## Use of Pre-Application Report

APPLICATION NO: 19/60200/PREAPP

PREAPP DESCRIPTION: Erection of two bed single storey bungalow

LOCATION: Land Rear of Ashgrove, Maldon Road, Hatfield Peverel

5 PROPOSED GROUND FLOOR PLAN
SCALE: 1:100 @ A1

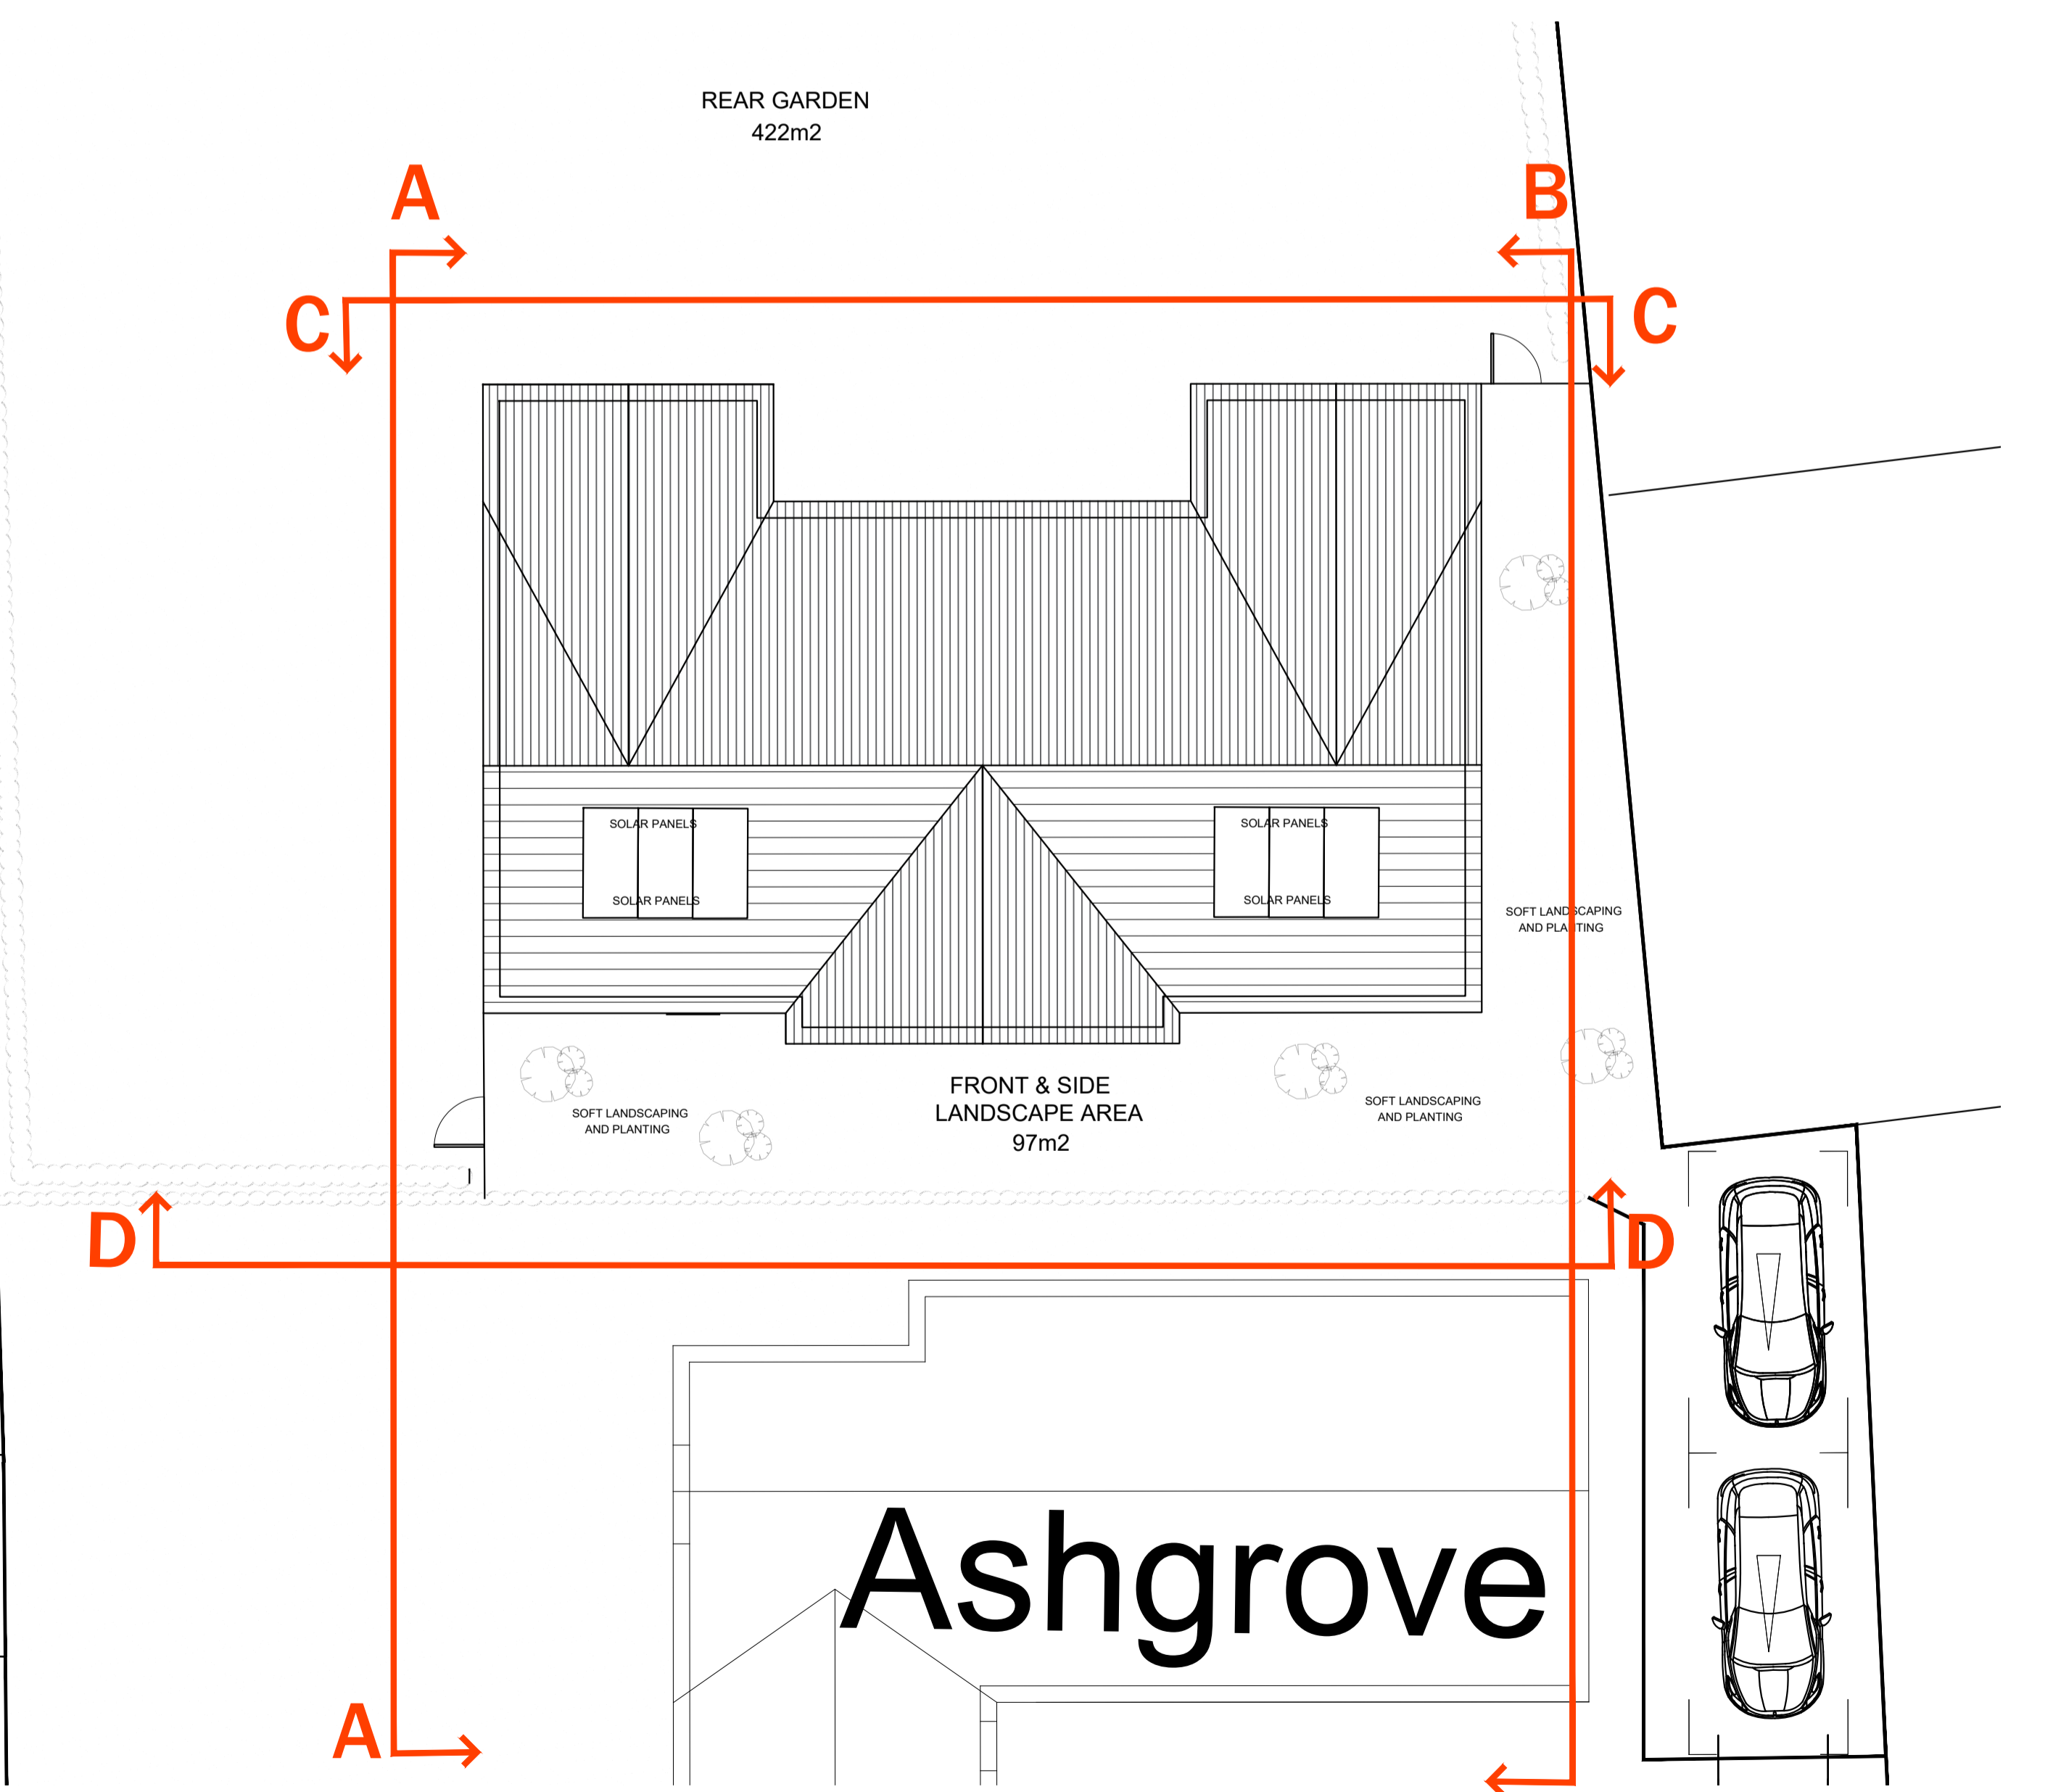
*In terms of detailed design, whilst the dwelling in itself raises no objections, but there are concerns with the size, scale and massing which is significantly larger than the retained dwelling to which it relates. As discussed within the meeting, Officers would also not support accommodation within the roof space. The proposal would not therefore accord with the relevant policies.*

**The proposed new dwelling is surrounded by a combination of mainly detached houses, semi-detached houses, chalet Bungalows and bungalows (which have Velux windows installed into their roofs, which demonstrates that they have used their loft space for potential amenity space) To which I believe was an unjustifiable reason for concern in the pre app report, as other properties around the plot have used their loft space for amenity. There is a variety of property types that create the characteristics of the surrounding area. I do not believe the new proposed dwelling would be harmful to the characteristics of the area but bring value to the area. For example, the mix of roof tile colours surrounding the plot is between slate grey colour and brown. In which the proposal suggests matching the same colour grey slate as multiple properties surrounding. Along with a mixture of brick (to match existing red facing brick) of the existing property, and cream/white render. To match the existing surrounding area.**

1 GROUND FLOOR PLAN
 SCALE: 1:50 @ A1

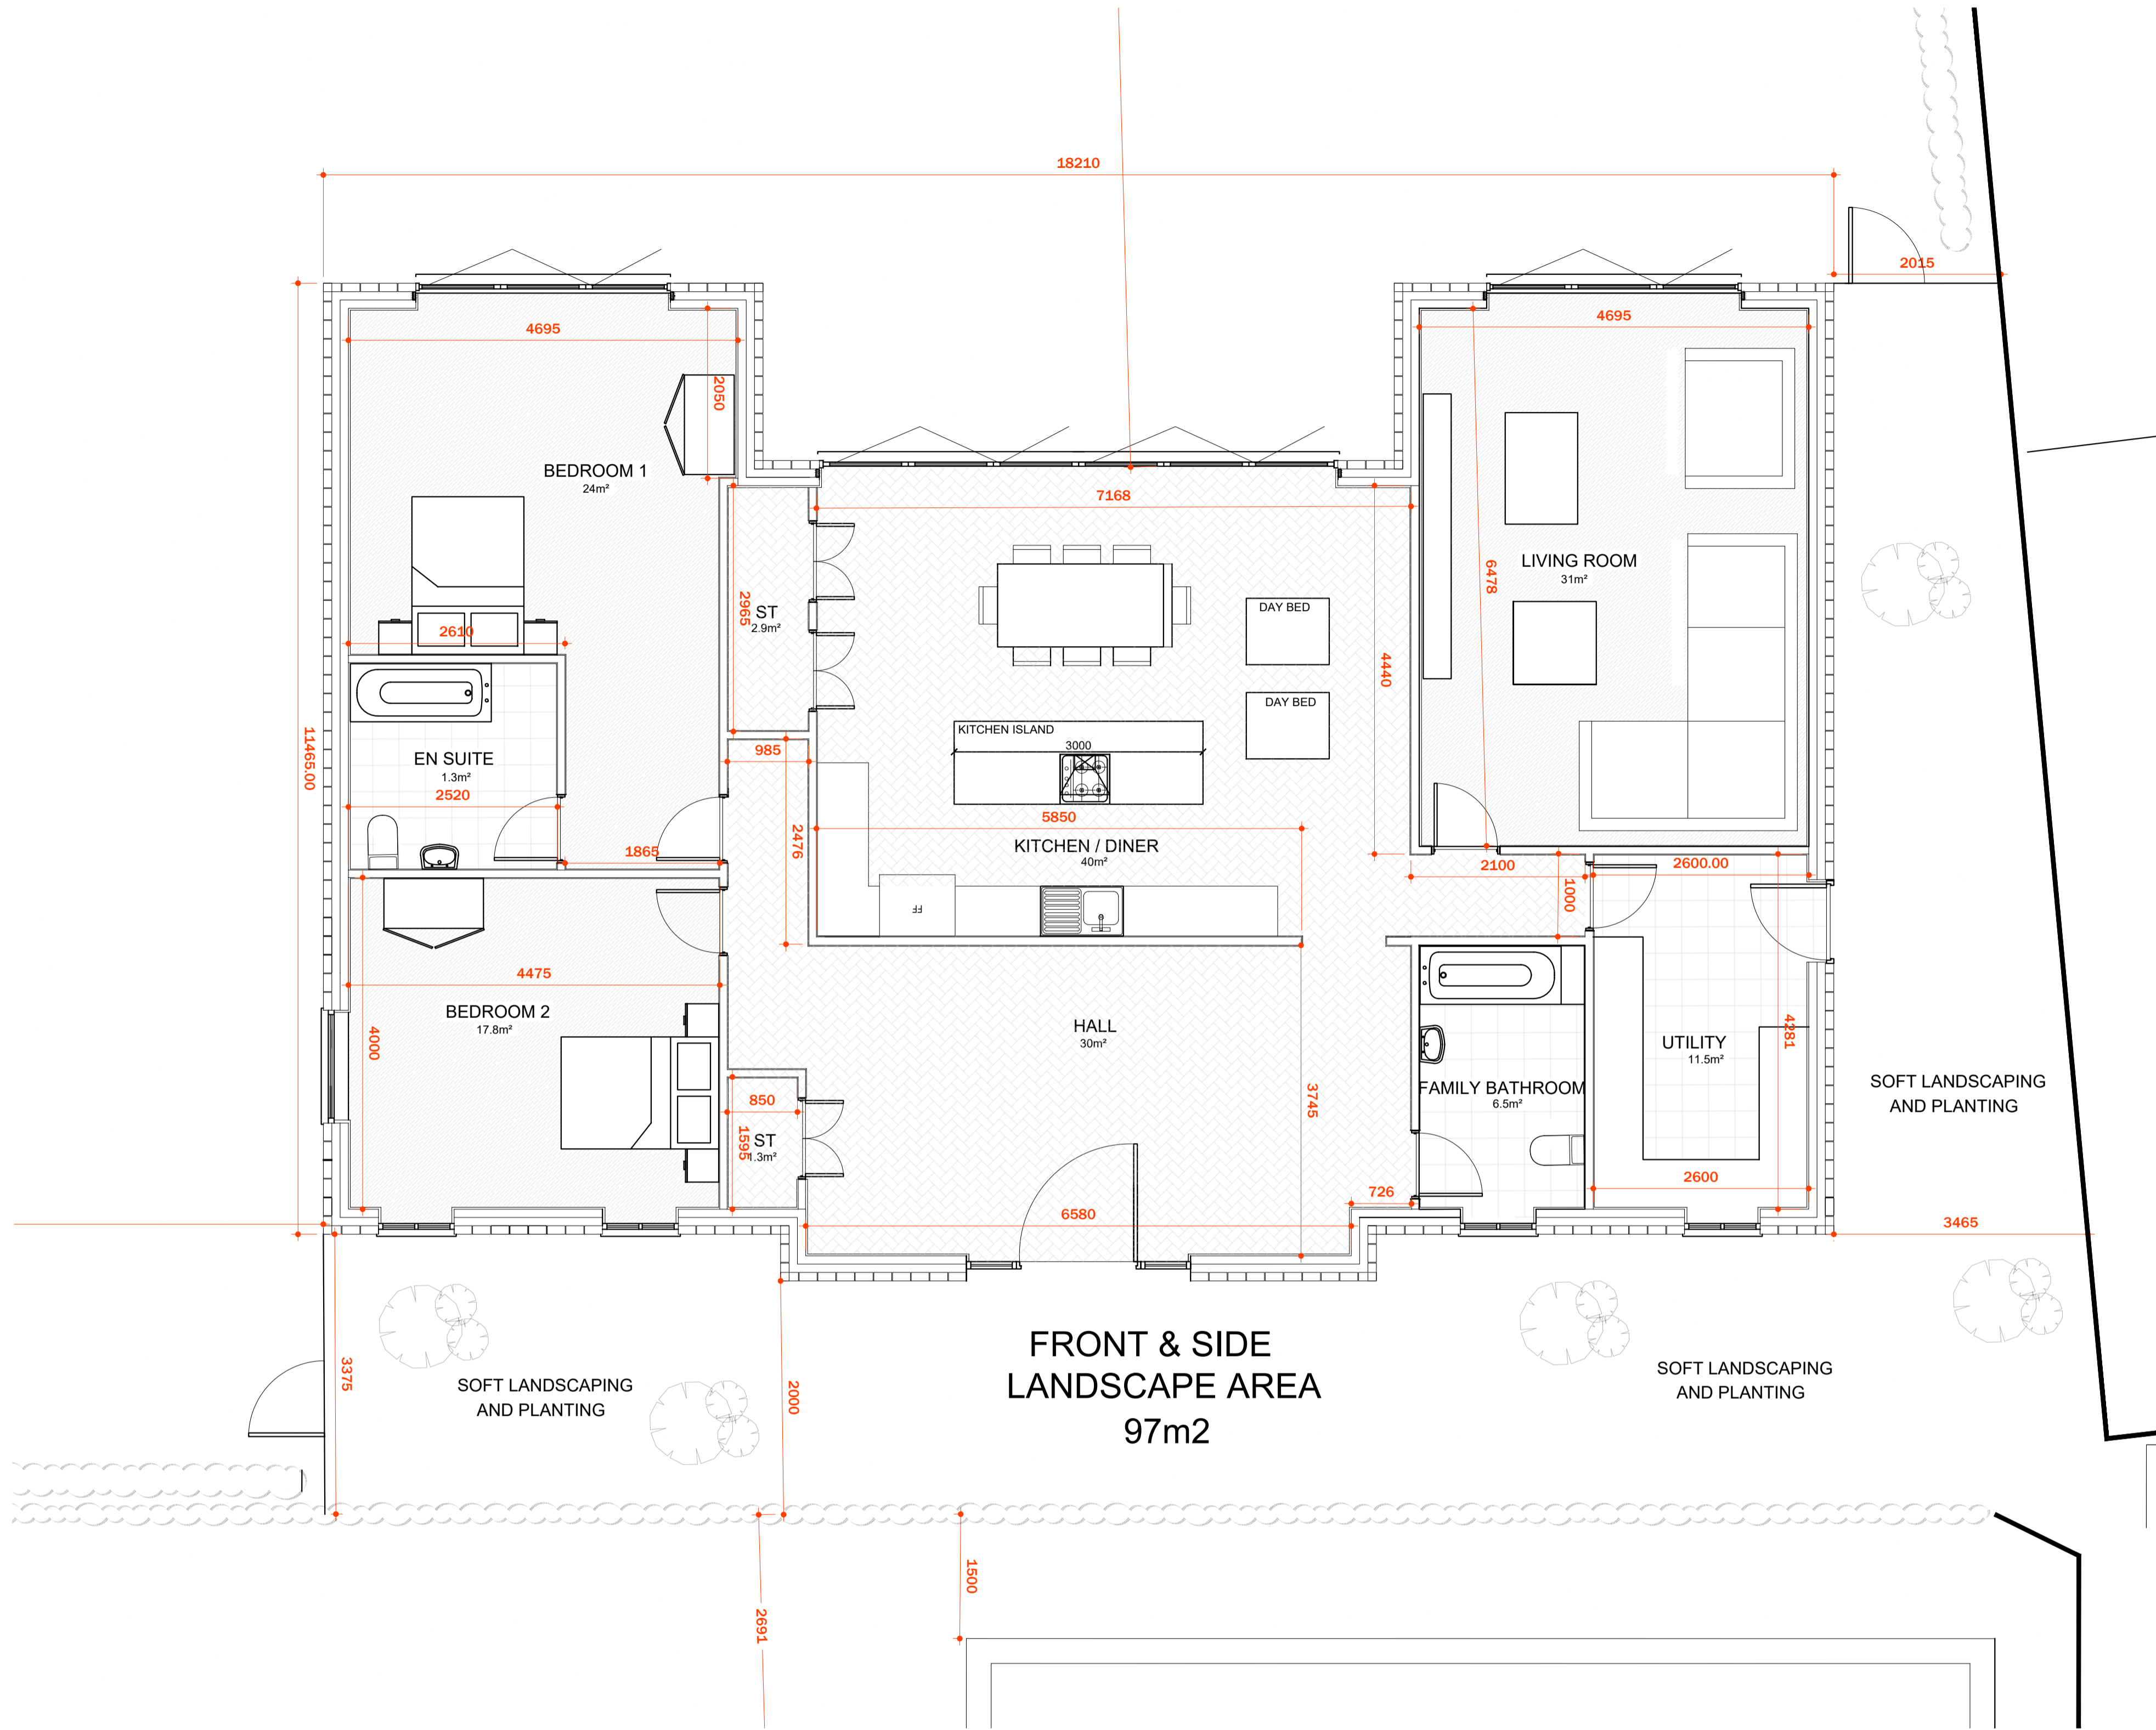
*The floorplans indicate that bedroom 2 will have an outlook onto the shared boundary (understood to be a fence). Given the proximity of this, it would result in poor amenity in terms of light and outlook. Whilst this may be acceptable for a bathroom, utility room or secondary window etc., it would be unacceptable for a bedroom. (Also note the proposed flank utility room door would not be accessible). The proposal would therefore not accord with the relevant policies.*

**Since the pre application meeting in 2019 (19/60200/PREAPP) The floor plan has changed to suit the above comments. (Internal and external). The bedroom at the front of the bungalow now has a primary window overlooking onto the garden, leaving the smaller two windows facing the boundary of Ashgrove as secondary windows. The smaller windows facing the shared boundary are now secondary windows, as preferred in the pre app comments. The access to and from the new position of the utility, is to the north and suffices sufficient space to access from the flank wall. I have c amenity.**

2 SITE PLAN
 SCALE: 1:500 @ A1

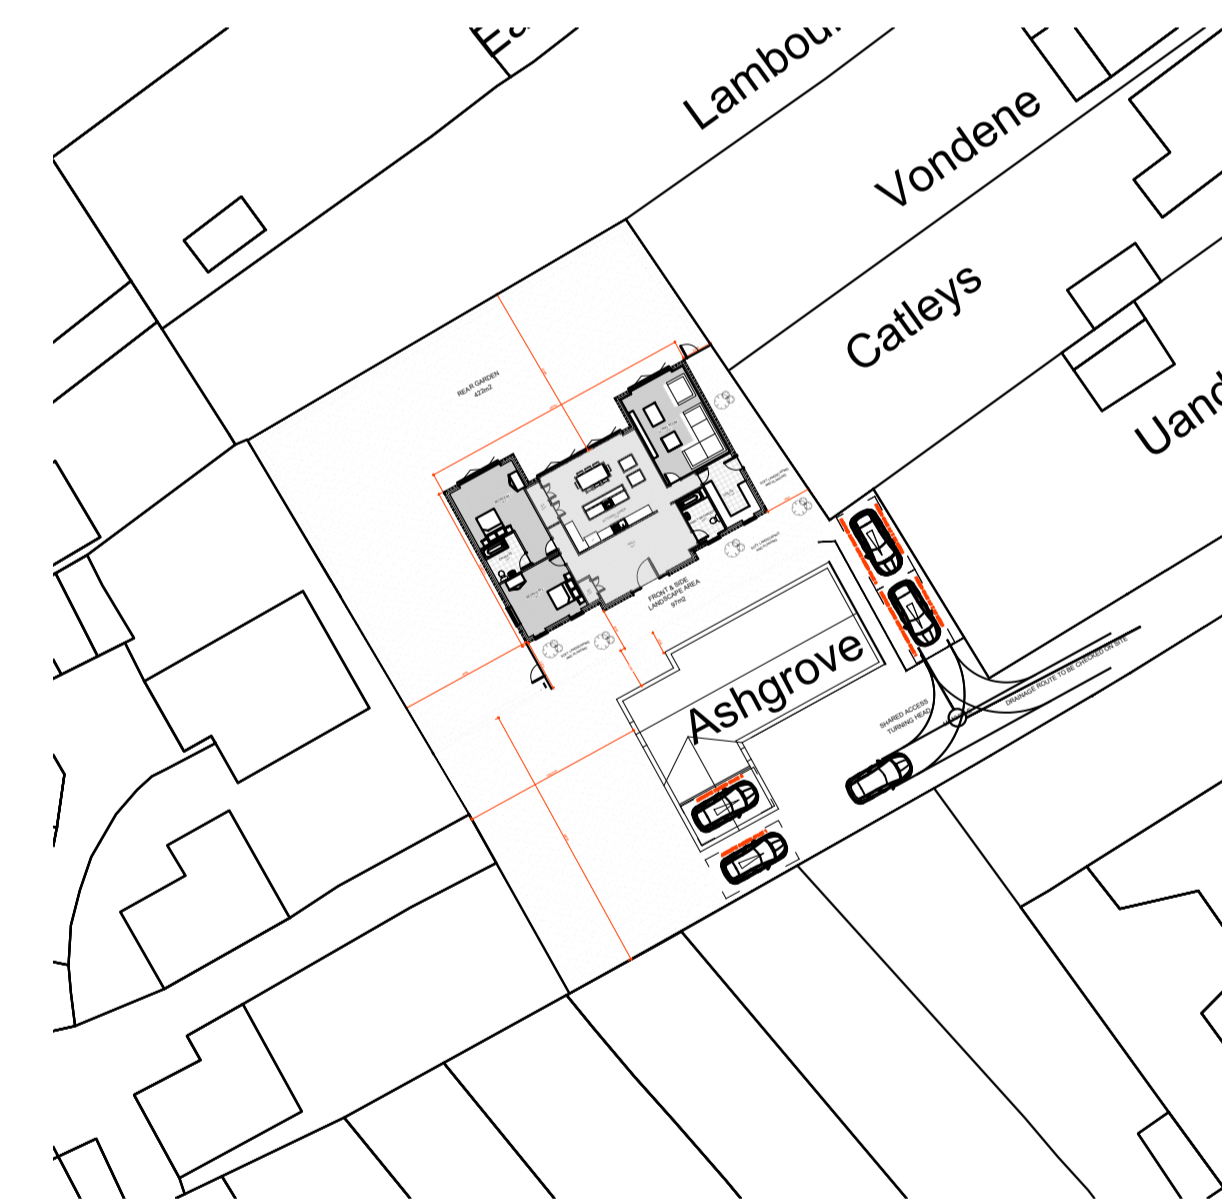
*The plans do not detail car parking provision for the retained or proposed dwelling. You are advised that 2 parking spaces would be required for each dwelling.*

*However it does not appear that this would be of sufficient size to accommodate 2 spaces (parking space standards are 2.9 x 5.5 metres).*

*Officers would not wish to have hard surfacing harsh up to the existing dwelling. It is also unclear whether adequate turning and manoeuvring can be accommodated to ensure that all vehicles exit the site in forward gear.*

*Any application (or on-going preapplication discussions) should detail parking layout and turning for the existing and proposed dwelling. Please note that the highway impact of the proposal (including the acceptability of any proposed new access or intensification of the use of an existing access) is a matter for Essex County Council Highways and you may wish to undertake a pre-application submission with them with regard to highway matters.*

**The proposal demonstrates where two parking spaces are provided in tandem parking for the proposed Dawson Grove bungalow. Also, on the plan, it states where the current existing bungalow has efficient space for two parking spaces plus a garage. The plan indicated the turning head for cars to move and turn around with sufficient space down the private drive. This ensures that all vehicles can exit the site in forward gear.**

**Also, the proposed bungalow allows for soft surfacing and soft landscaping at the front of the property, and leading towards Ashgrove as demonstrated, and annotated in the plans.**
